CITY OF PORTLAND BUILDING PERMIT

Located At 225 BRADLEY ST

Job ID: 2012-05-4044-ALTR

has permission to Build 10' x 10' deck

Proposed Plan  
285 BRADLEY

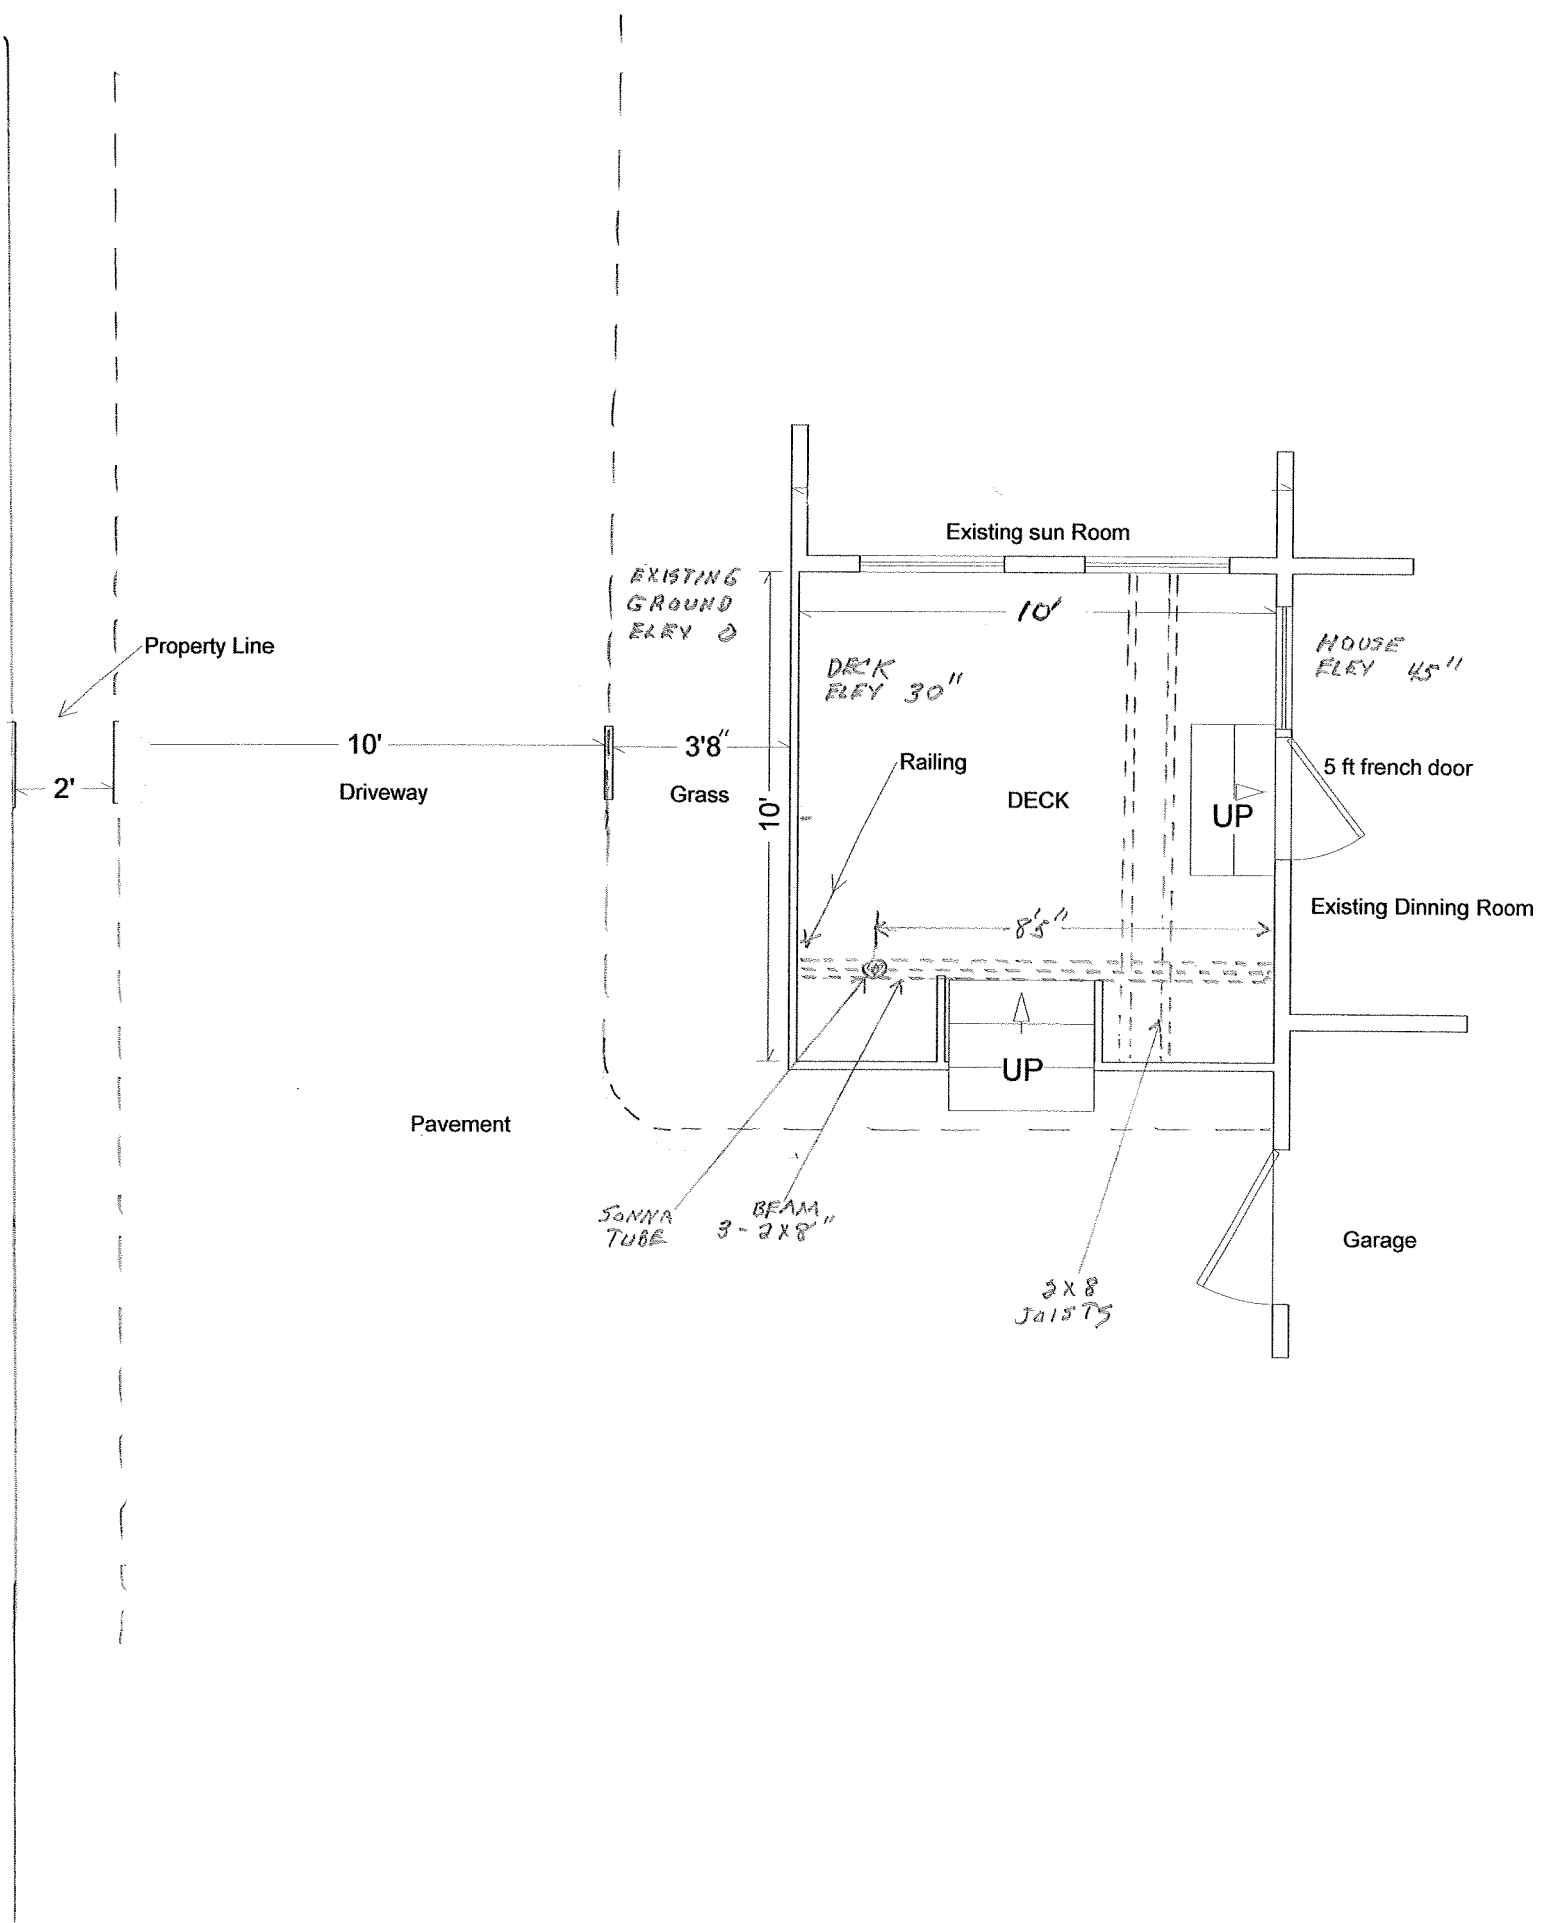
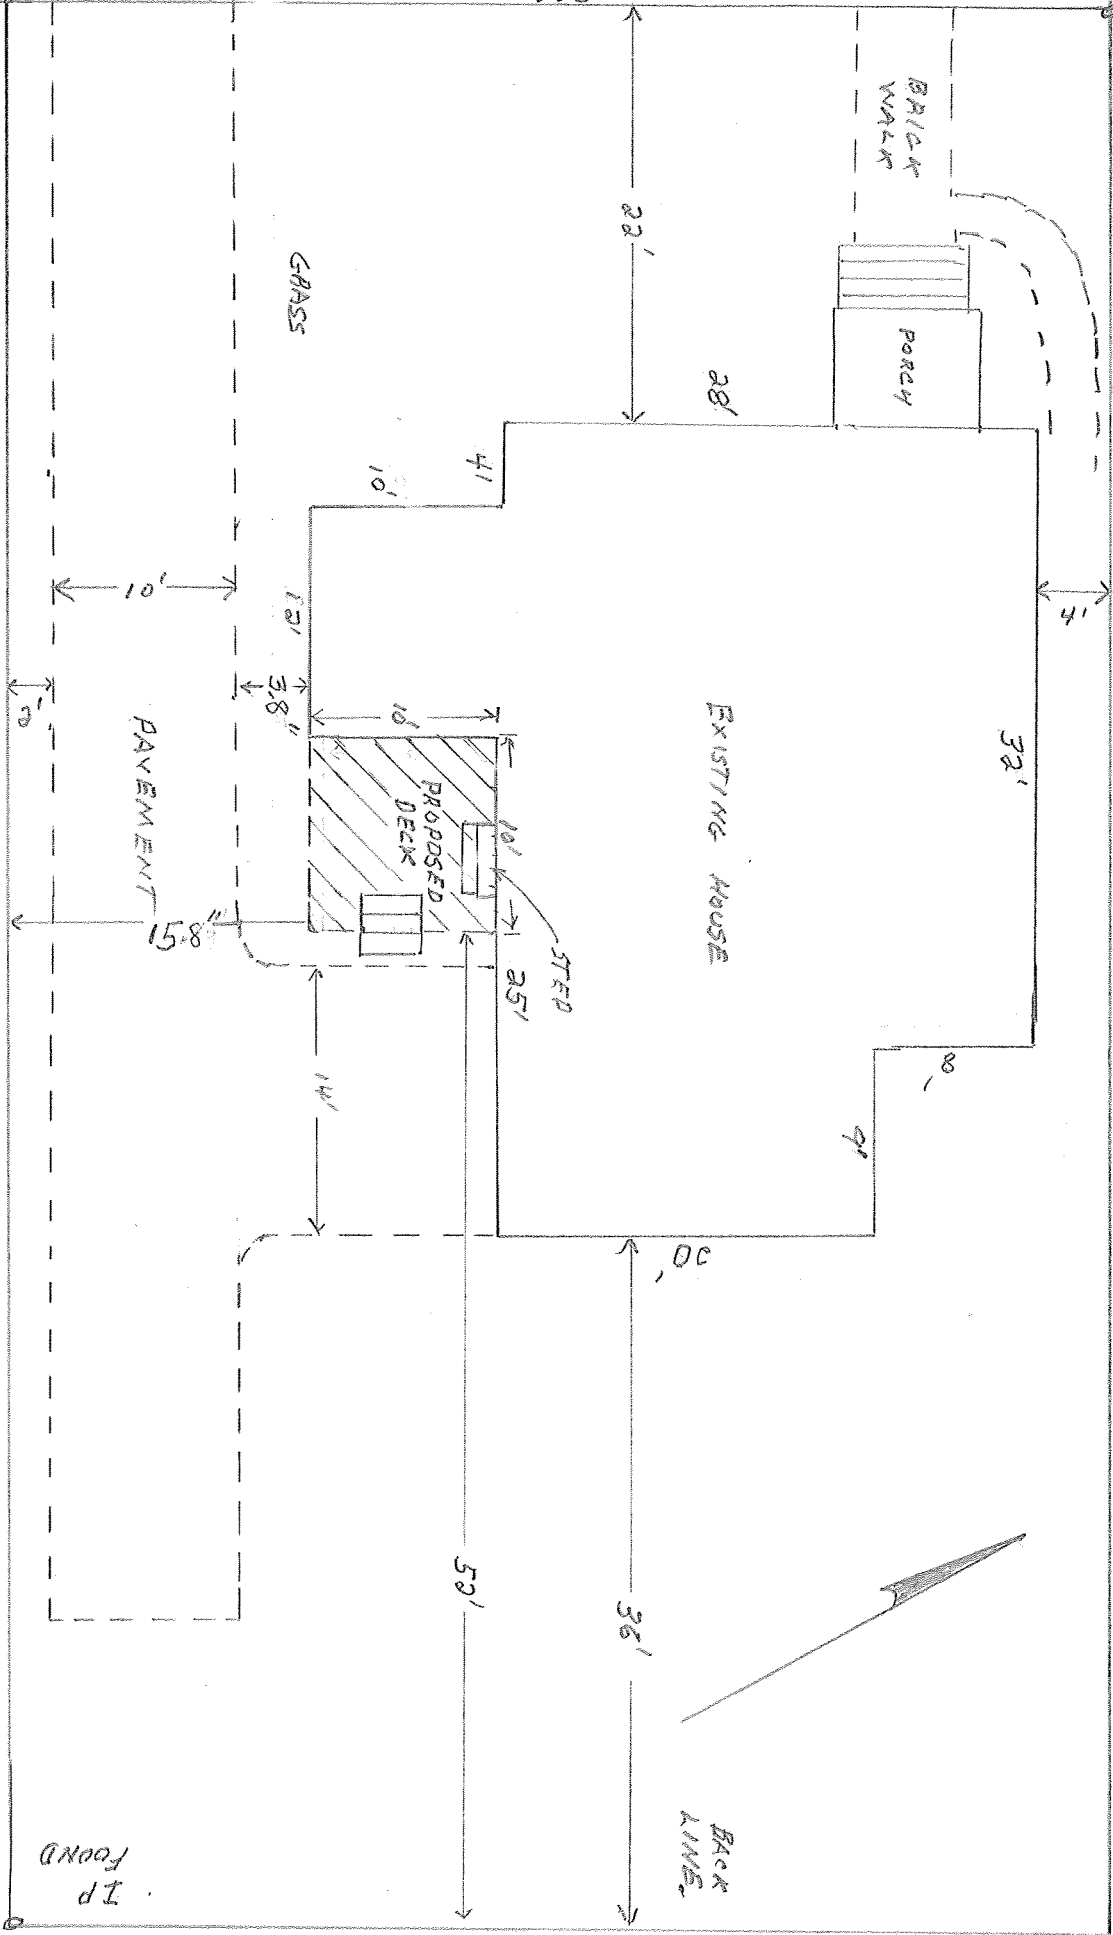
The main carrying beam must be 3- 2" x 12"-s
